Application number: 2023/90348	
What is the application for?:	Erection of community sports complex (within a Conservation Area)
Address of the site or building:	Former Hillhouse Bowling Club, King Cliff Road, Birkby, Huddersfield, HD2 2RR
Postcode:

Type of comment: An objection	
Do you wish your comments to be published on the website anonymously?	<input type="checkbox"/> Yes
<p>I do NOT wish my name, postal address or any reference in the text to my address to be published.</p> <p>Greetings Sir/Madam,</p> <p>I'm writing to express my opposition to the planned construction of a neighbourhood sports complex (Black Metal Box). While I recognise the value of having sports facilities in our area, I firmly feel that this plan should not go forward for a number of issues.</p> <p>Firstly, this proposal of the sports complex is</p> <p>and if the proposal was to go ahead there's a possibility of increase in noise and crime rate as it attracts all age ranges, traffic issues and much more for example the sun path was missing on the site plan in which is most important as if this structure is to be approved, then the sunlight will disappear affecting as well as other factors</p> <p>Also, in t

GROUND FLOOR
 1 : 200

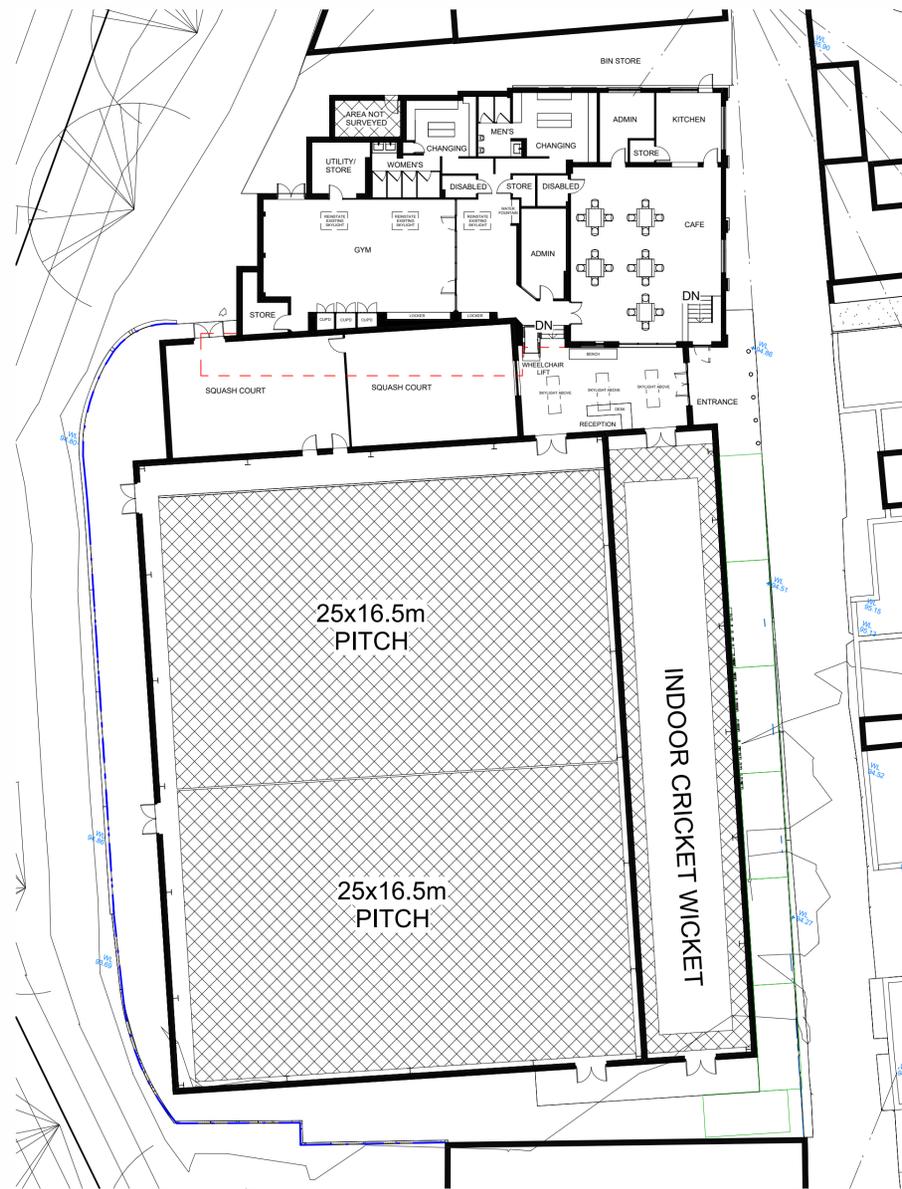
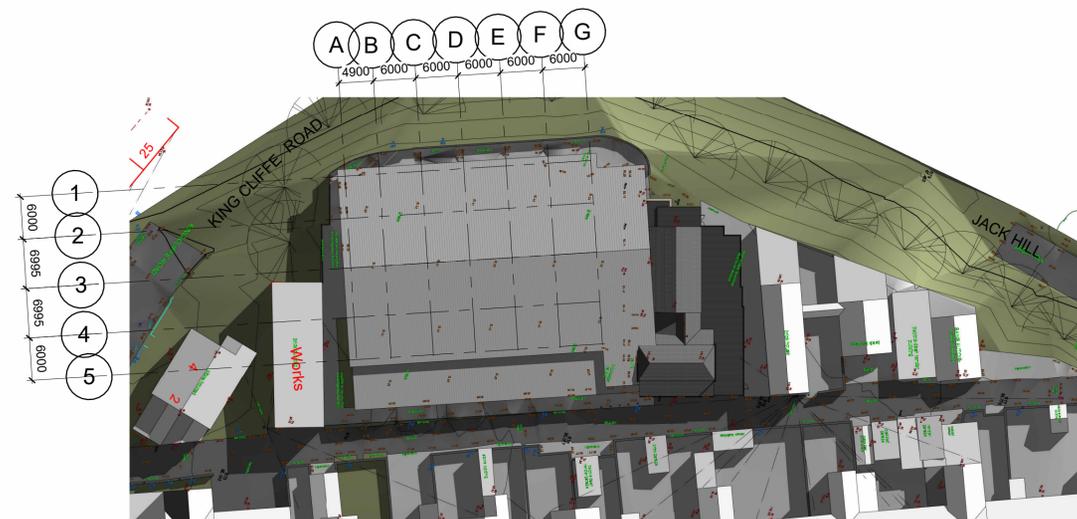
There would be demand for parking for up to 7 more vehicles on the congested street as there are no parking on site in the plan, causing congestion on the unadopted residential road. The applicant has not provided evidence that the building's sewerage system has the capacity to cope with the additional 6 sitting and 2 standing toilets as the floor plan drawing indicates.

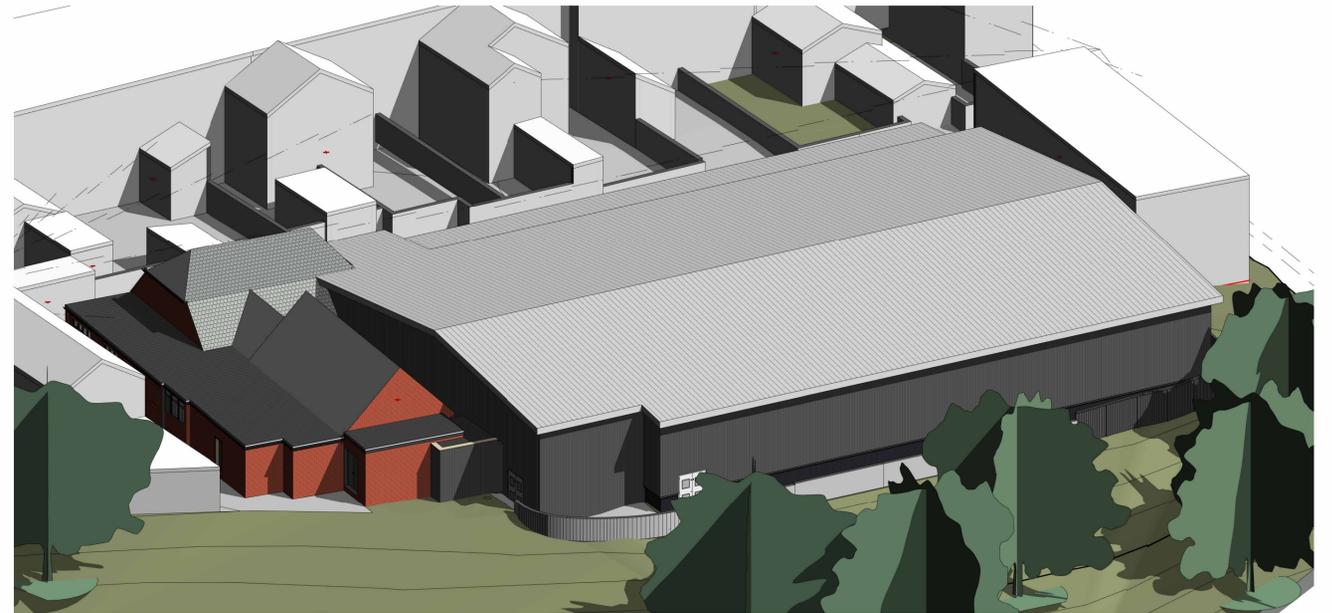
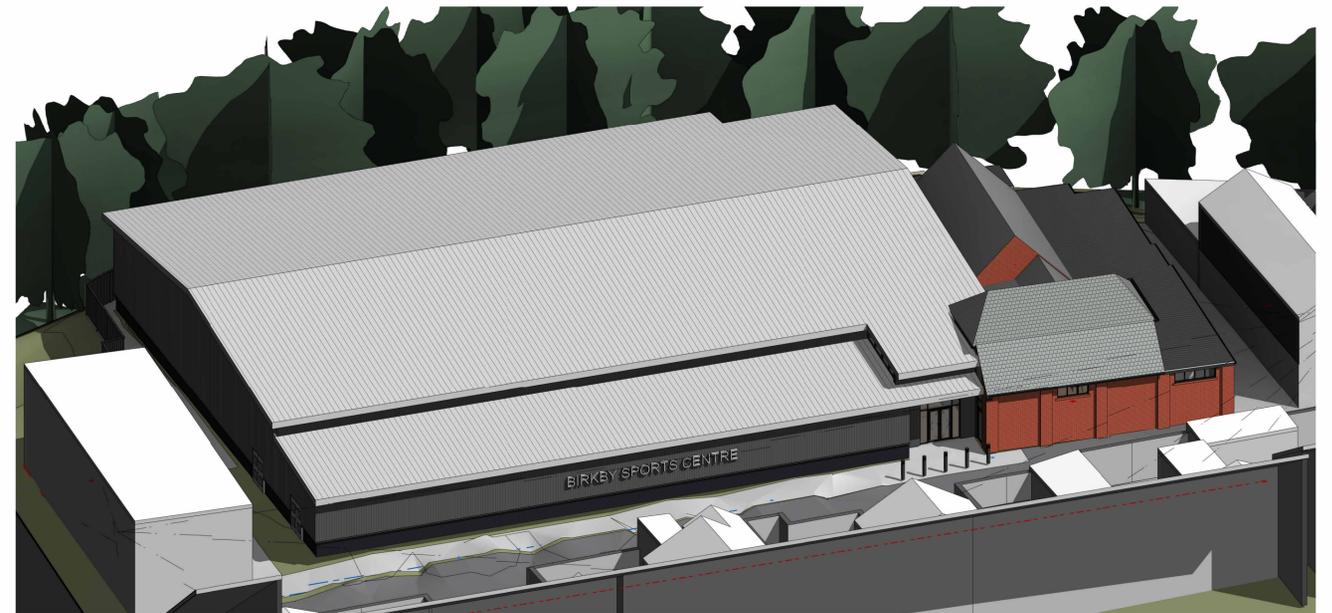
greater extent than the current building. The proposed choice of cladding (Black Sheeting Cladding) is unsympathetic to the character of the local area. There are no buildings anywhere in the surrounding streets with this type of cladding and will make the residential area not feel homely or welcoming it would change the residential area to look like an industrial estate.
